From: Christopher Lidman
To: Steve Coyne: "gillian"
Cc: Christopher Lidman; Brian Cole
Subject: Re: Lighting report
Date: Tuesday, 12 November 2019 5:53:31 PM
Attachments: [image002.png](#)
[image003.png](#)

The SSO Dark Sky Committee has read through the report, and have provided the following feedback:

Hi Chris,
The report on the Dark Sky implications of Vickery is attached.
I would be interested in any comments.
If you have any particular technical queries, Steve Coyne from Light Naturally has indicated that he is happy for you to contact him for clarification.
Regards

Figure 7: Composite luminance image of night sky showing vertical planes of analysis for anthropogenic sources over Maules Creek (green dashed line) and Boggabri region (green dotted line) and the red line shows adjacent dark sky area for the 'near background' reference.

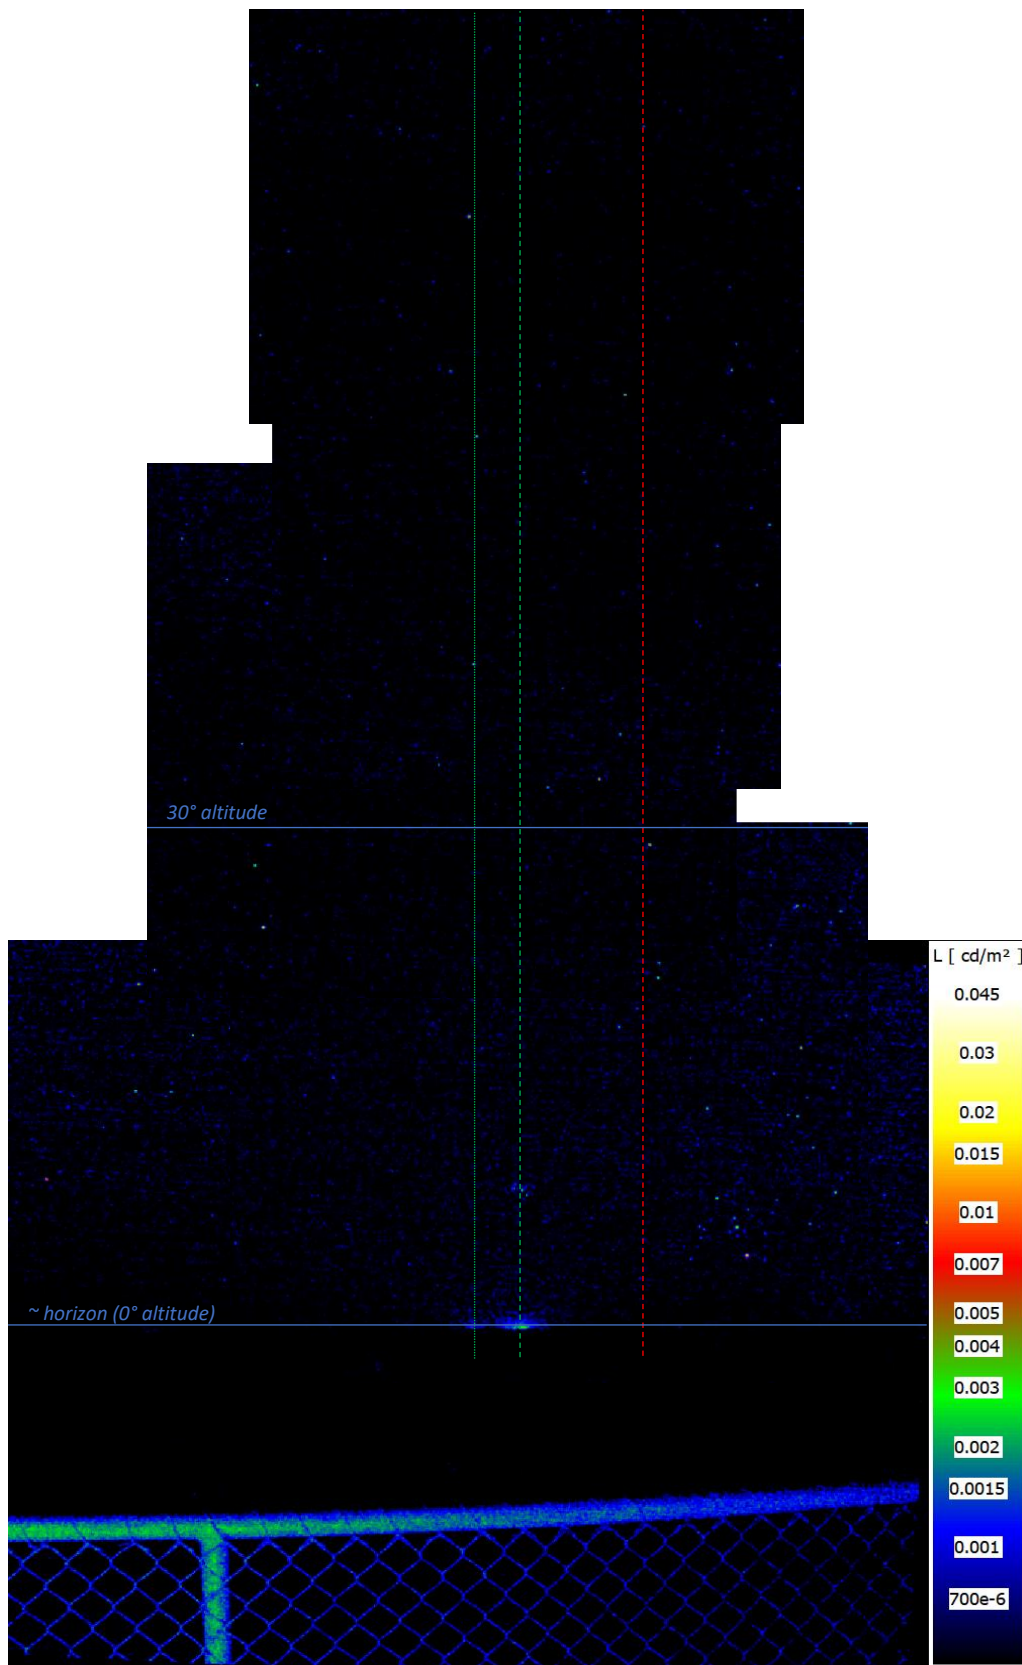
I understand the reasons you chose an azimuth angle of 65 degrees as the reference. Looking at the orientation of Taurus and Pleiades in Fig 7 and Fig 8, I estimate that these images were taken around 1 am at the beginning of September. Here is a direct link to the view that was imaged: https://in-the-sky.org/skymap.php?no_cookie_1&latitude=-31.25&longitude=149.20&timezone=10.00&year=2019&month=9&day=1&hour=1&min=0&PLimitmag=2&zoom=166&ra=3.08952&dec=10.60846

Figure 15: Source to Darkest Background Ratio (value 1.0 indicates little or no anthropogenic effect, dashed line shows the threshold limit of natural background +10%) for Maules Creek and Boggabri sources, compared to the darkest background reference

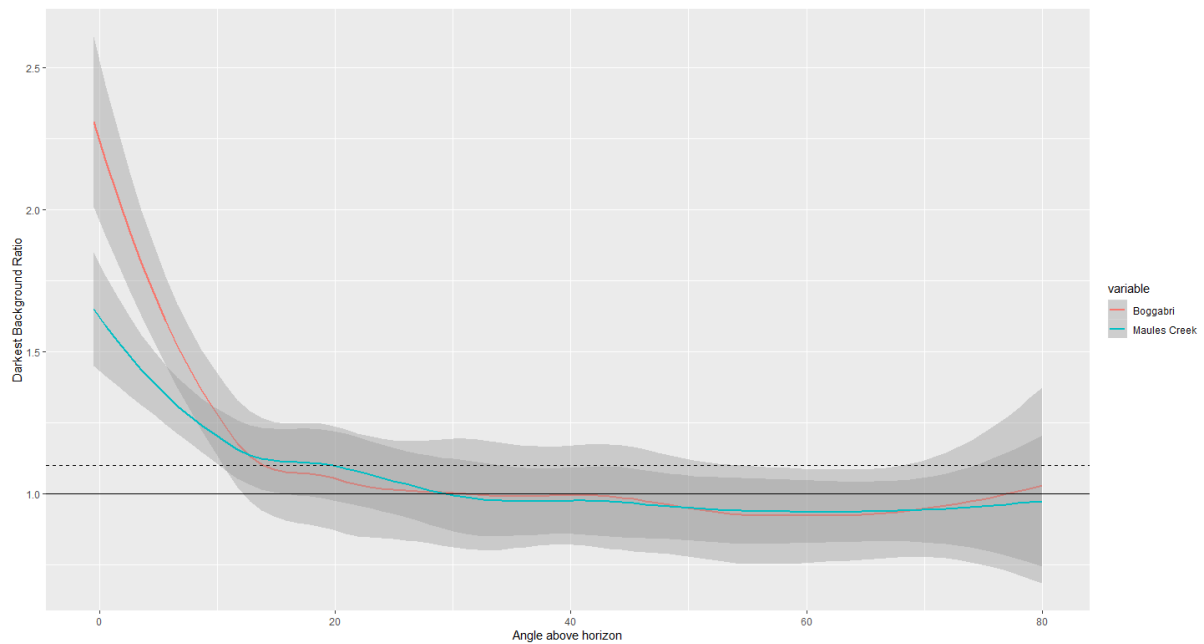
Even with the uncertainties, it is clear that the current lights from the Boggabri mine lies below the 10% threshold at an altitude of 30 degrees. Indeed, the little bump at an altitude of 20 degrees in Fig 15, may be the Zodiacal light. If one were to remove that, then the 10% threshold is reached when the altitude is 15 degrees, and we do not point telescopes that low in the sky.

Figure 18: Comparison of Simulated and Measured Luminances for increasing Altitude above Horizon over Maules Creek Mine under Clear Sky

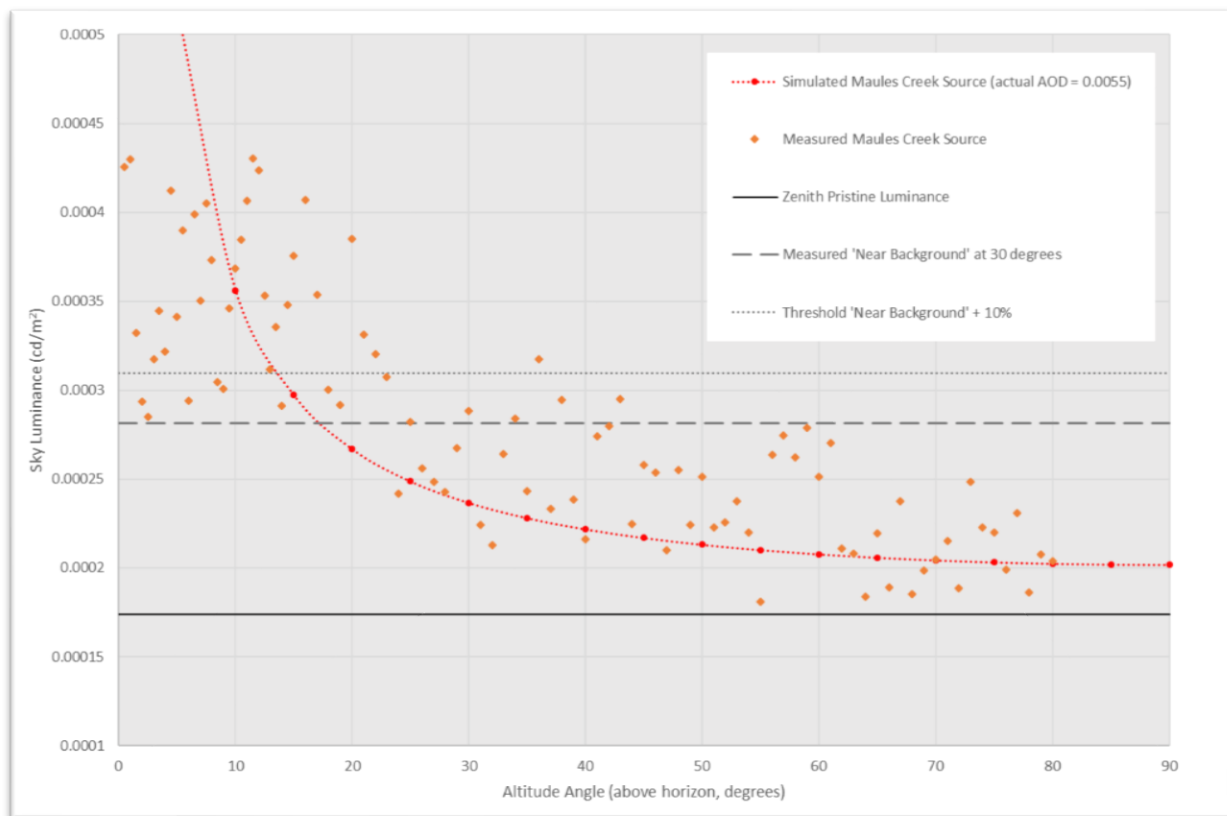
- We anticipate that the red dotted curve in Fig 18 consists of natural and anthropogenic sources. How much of the increase towards lower altitudes is due to the natural increase with decreasing altitude?

- We anticipate that the red dotted curve in Fig. 18 consists of natural and anthropogenic sources. How much of the increase towards lower altitudes is due to the natural increase with decreasing altitude?
- There are four dotted curves in Fig. 19. It was not clear from the caption or the text what distinguishes these four curves.
- The report notes a total luminous flux of 6.96×10^6 lumens and that 24% of that (1.67×10^6 lumens) would be directed upwards. On page 23, it seems that the total luminous flux was used in the Sky Glow software. Does the Sky Glow software take into account that only 24% of total luminous flux is directed upwards?
- We acknowledge the comment that upward light spill could be reduced with best practice light design.

I understand that red dotted line is the sum of the anthropogenic source used in the model plus a constant background. This seems to be a limitation of the software, as I would expect that most of the increase between 90 degrees and 20 degrees is entirely natural.

Figure 19: Comparison of Simulated and Measured Luminances for increasing Altitude above Horizon over Maules Creek Mine under Clear Sky with variations in simulated AOD

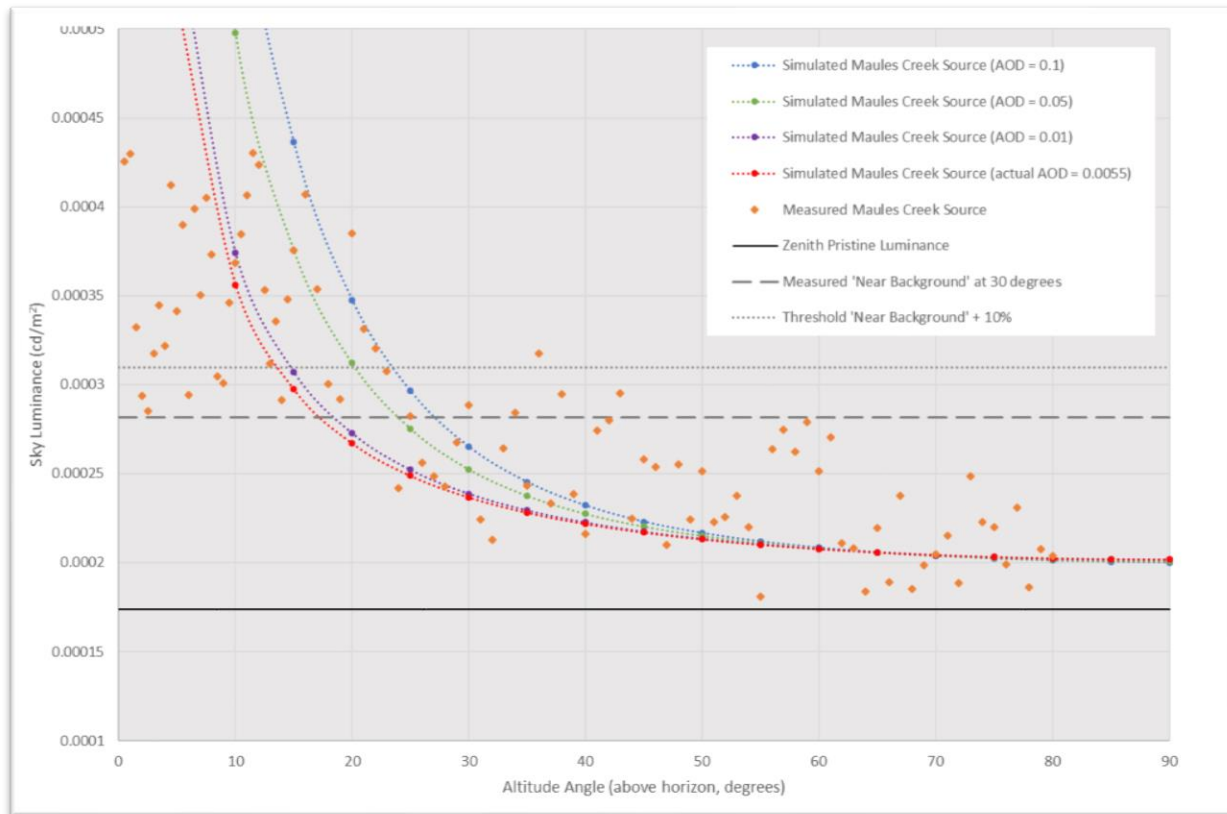
- There are four dotted curves in Fig 19. It was not clear from the caption or the text what distinguishes these four curves.

You explained this well enough. I blame my failing eyesight for not interpreting this plot correctly the first time.
